From: Ian Brewster
Sent: 14 December 2011 16:42
To: James Smith
Subject: LY/22/11/T Lyminster Court Lyminster Road Lyminster BN17 7QF

I met with Mr Reagan at the above address today at 10.30am (14th December 2011) to discuss the conifer hedge felling and the tree work to the Evergreen Oaks.

Four
Lyminster Court TPO - G1 - ~~8~~ Holm Oak trees

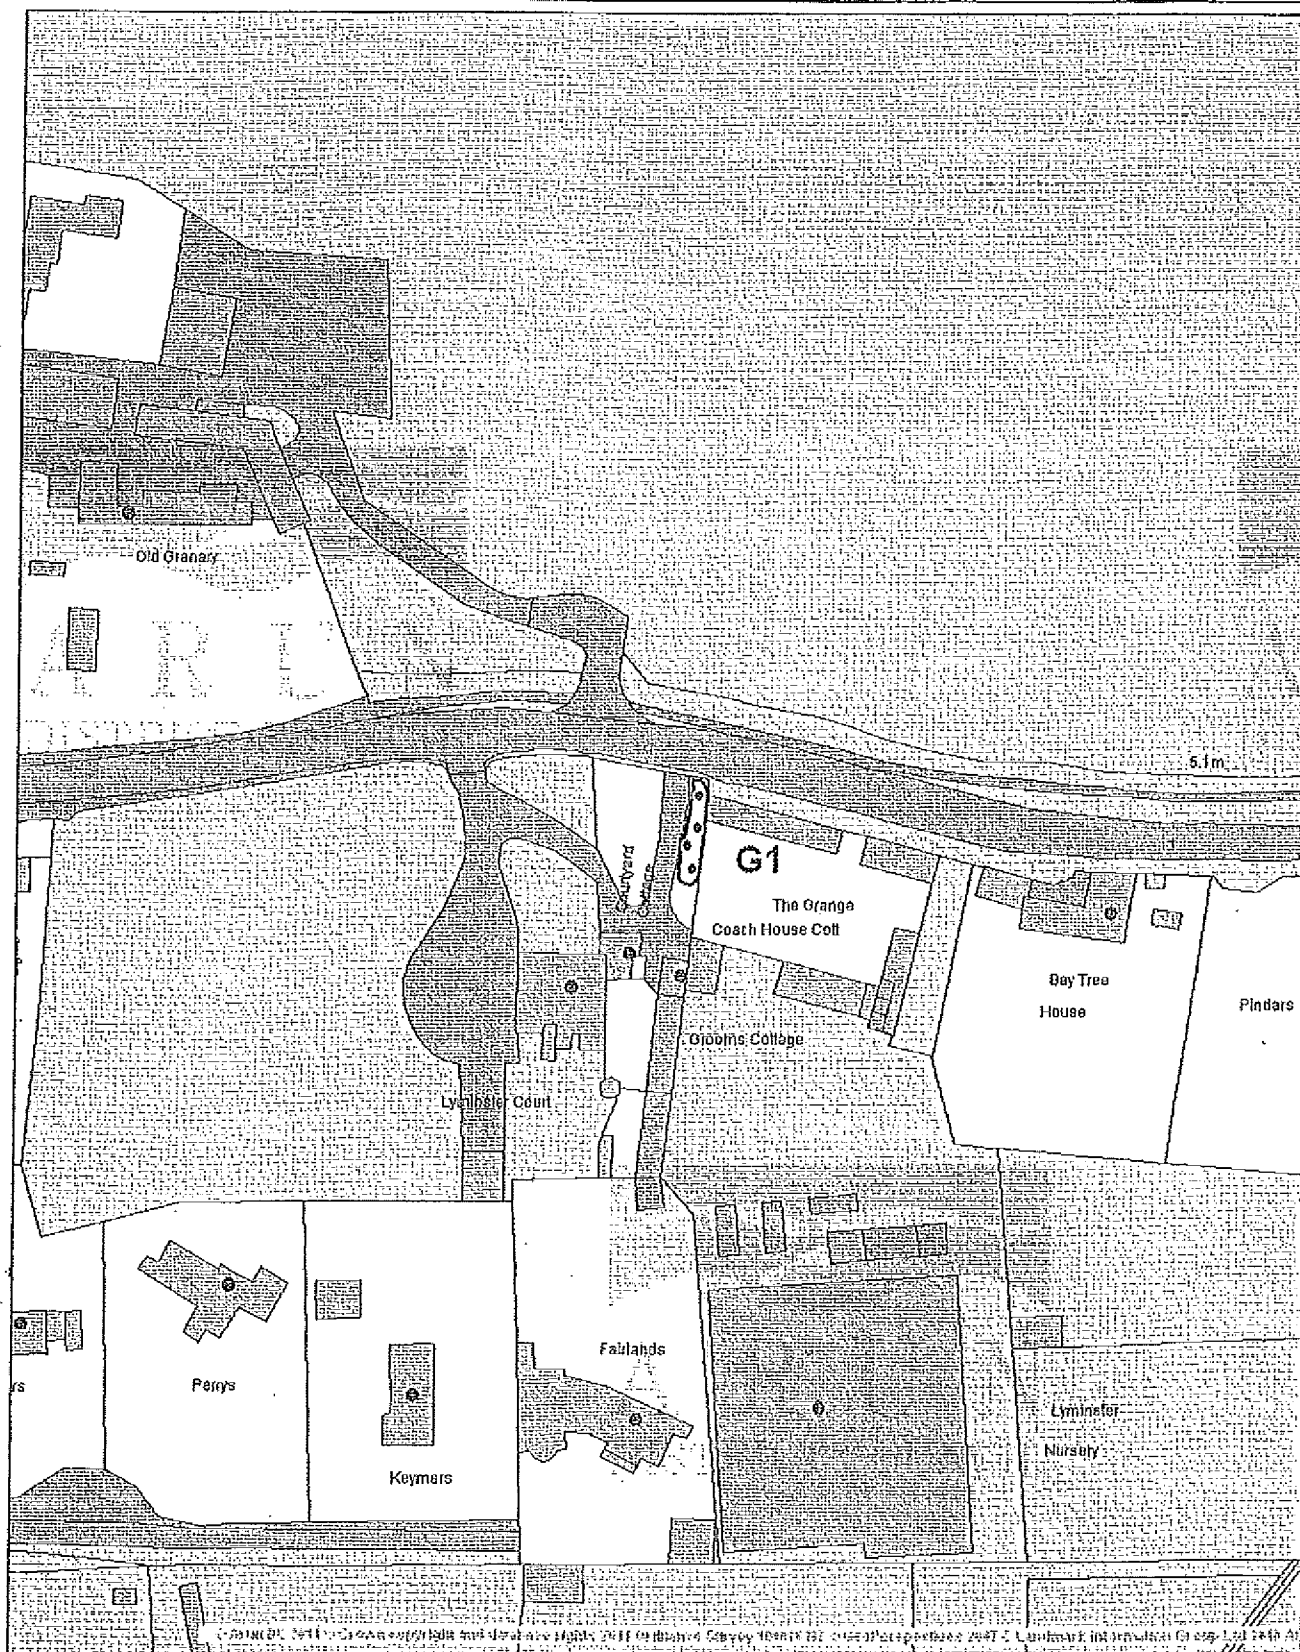
The first three Evergreen Oak trees from the Highway to be Crown Reduced by 3m. The branches to be cleared from the single storey neighbouring property by providing a gap of 2m. The 1st Evergreen Oak which overhangs the highway to be crown lifted to 5.2m.

The fourth tree and one farthest away from the highway and nearest the house should not be reduced. It should only be crown lifted over the boundary wall by 3.5m.

To provide adequate clearance from the highway and adjacent private property. To reduce the potential for limb collapse from the first three trees due to tight forks and cavities affecting the primary branch structure.
